CDR20005-V2-CDs-SRR.pdf Markup Summary

CDR-20-005

**VOLLMER SOUTH CL PROFILE**  
**STA 9+50.00 TO 24+00.00**

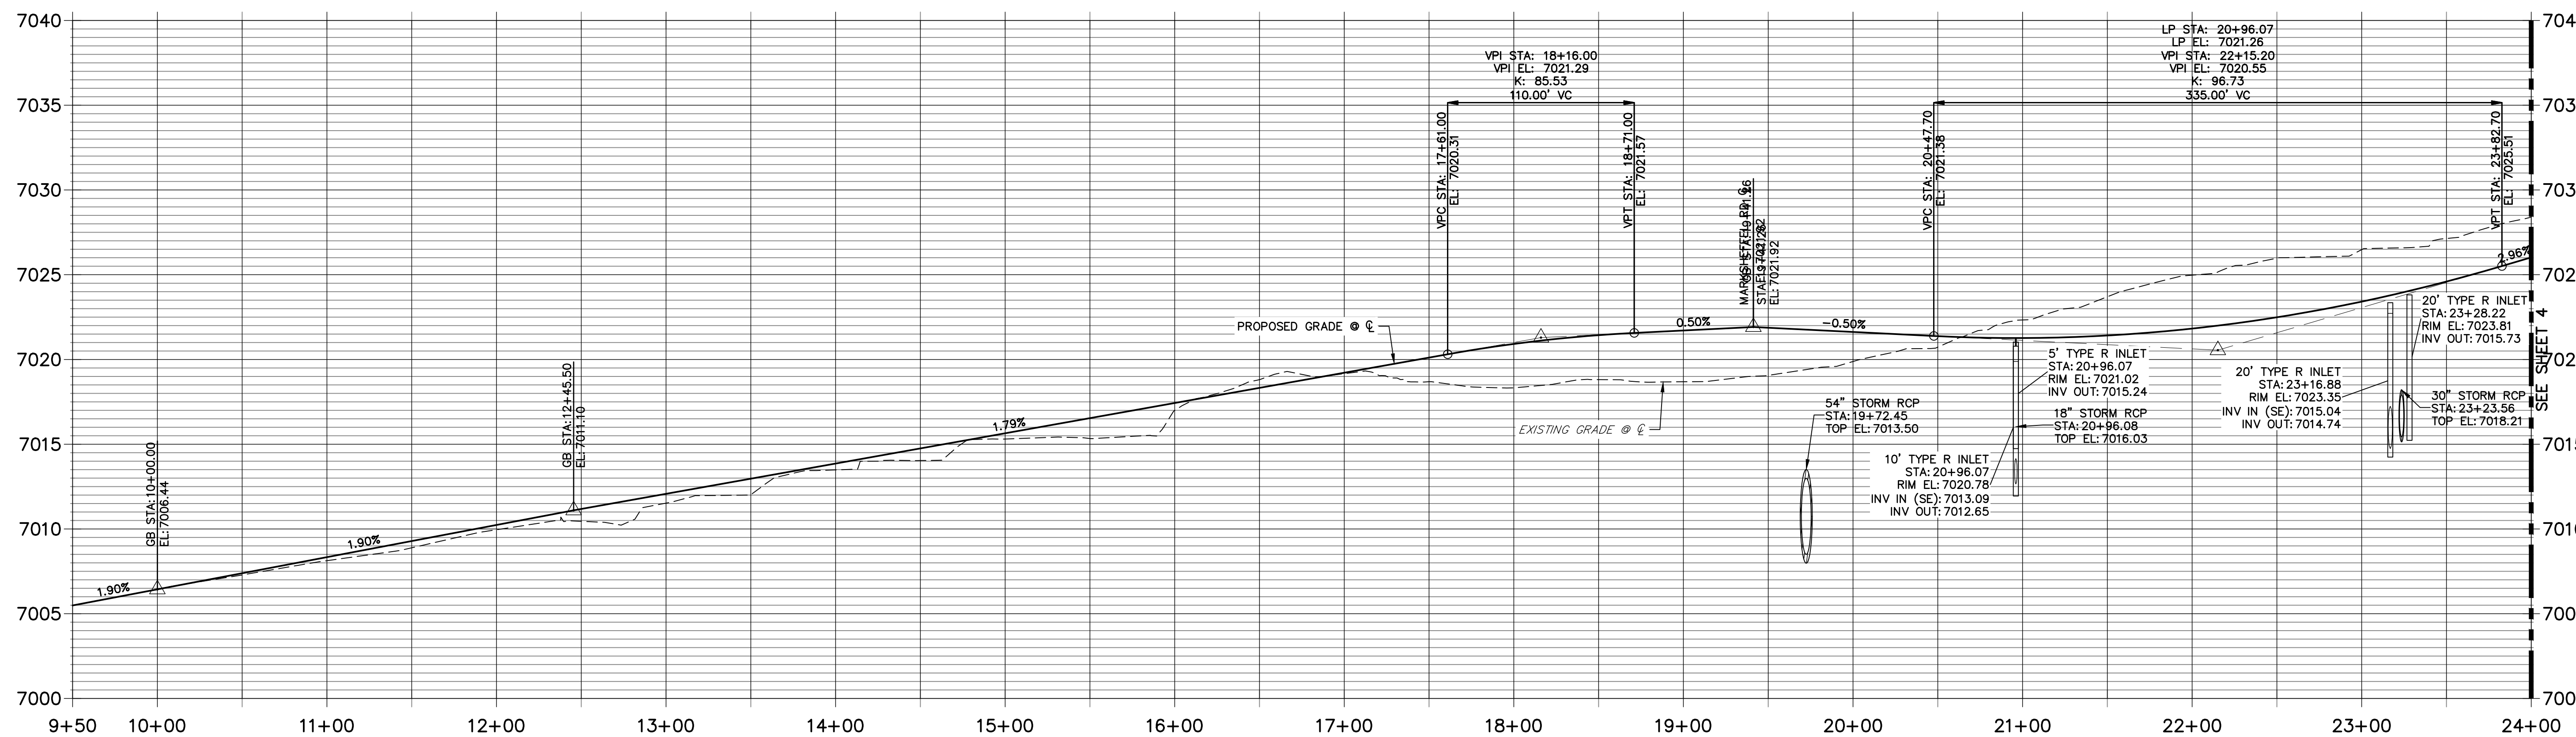
Provide a centerline profile for the necessary distance to show that criteria is met.

**VOLLMER ROAD SOUTHERN TIE-IN TO EXISTING**

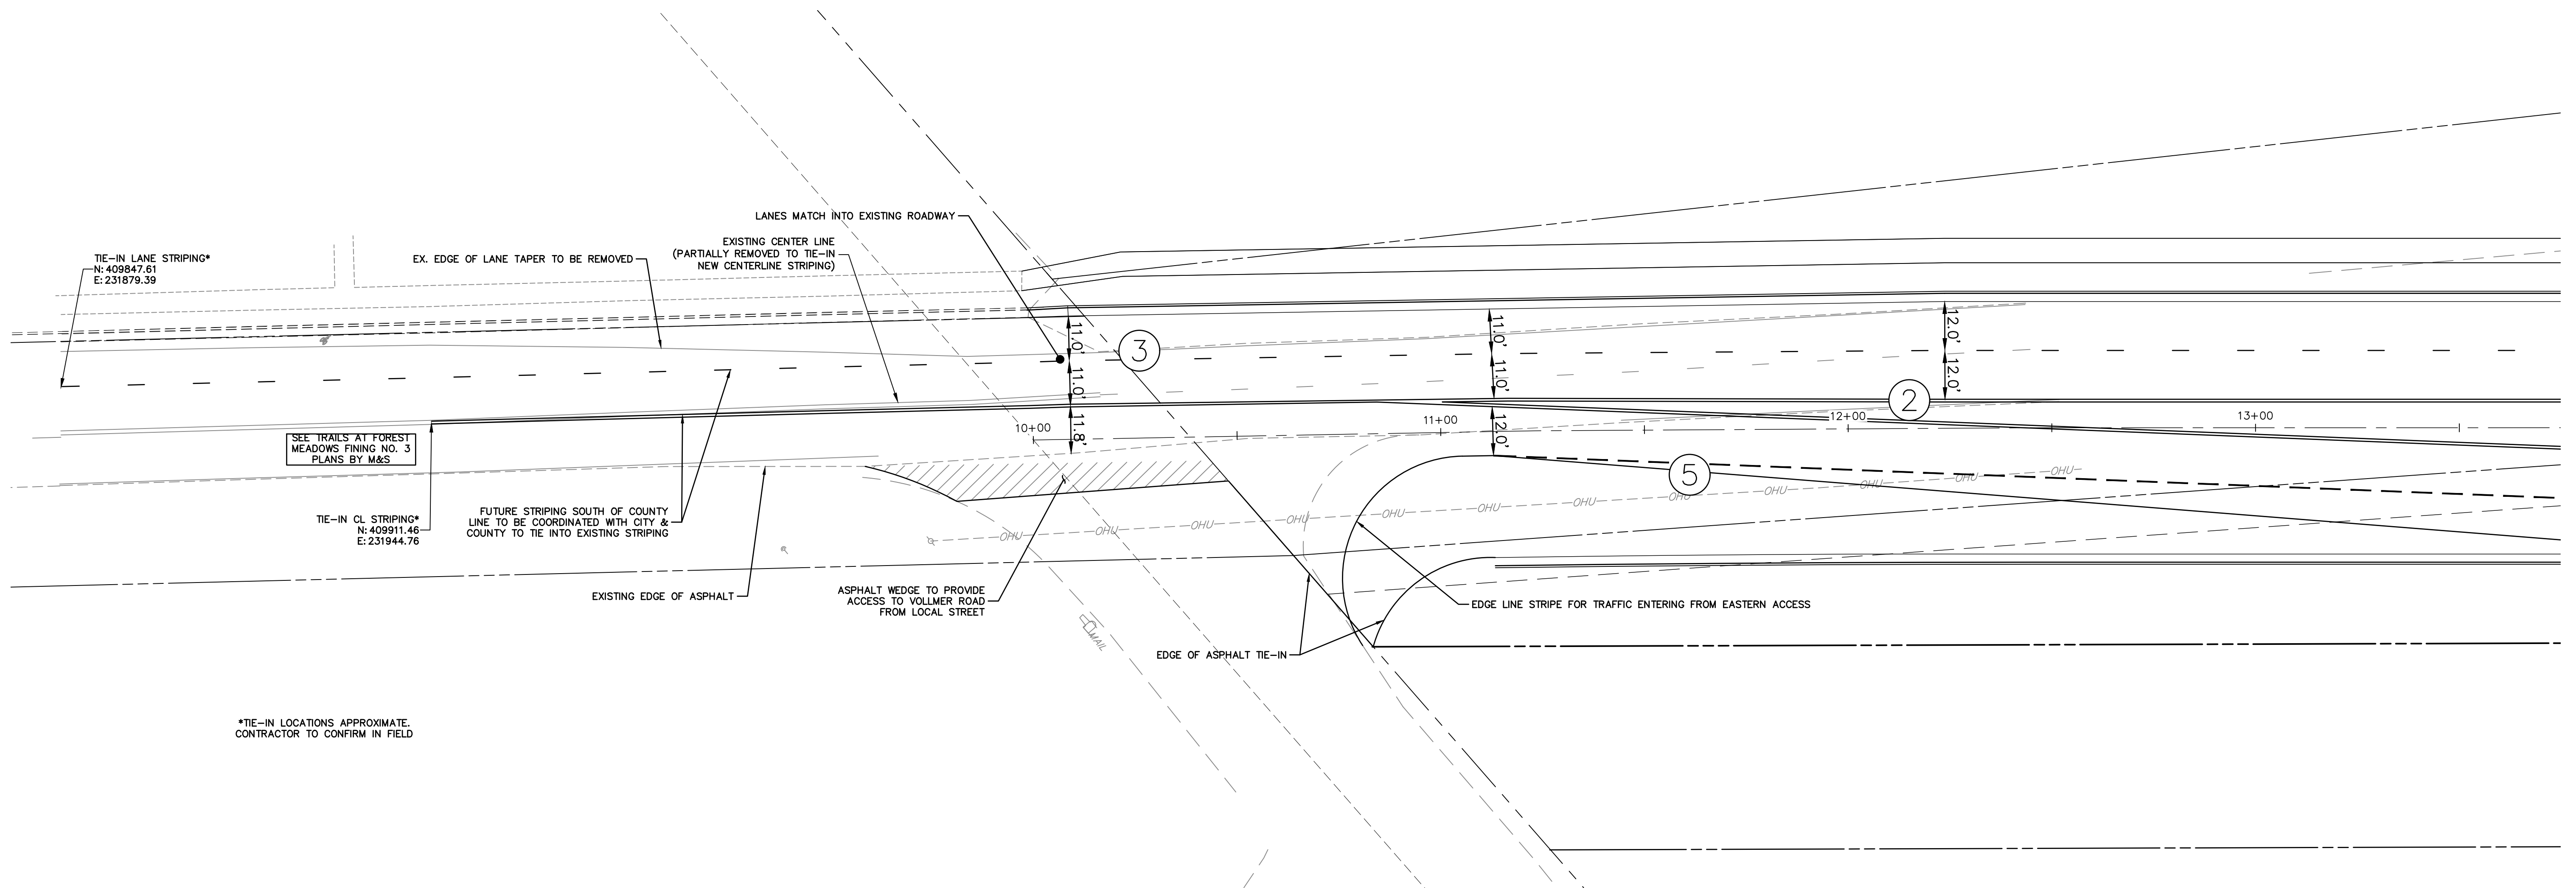
Verify that the length of this left turn lane will be adequate or if two left turn lanes will be needed.

Coordinate all "1"s / "2"s
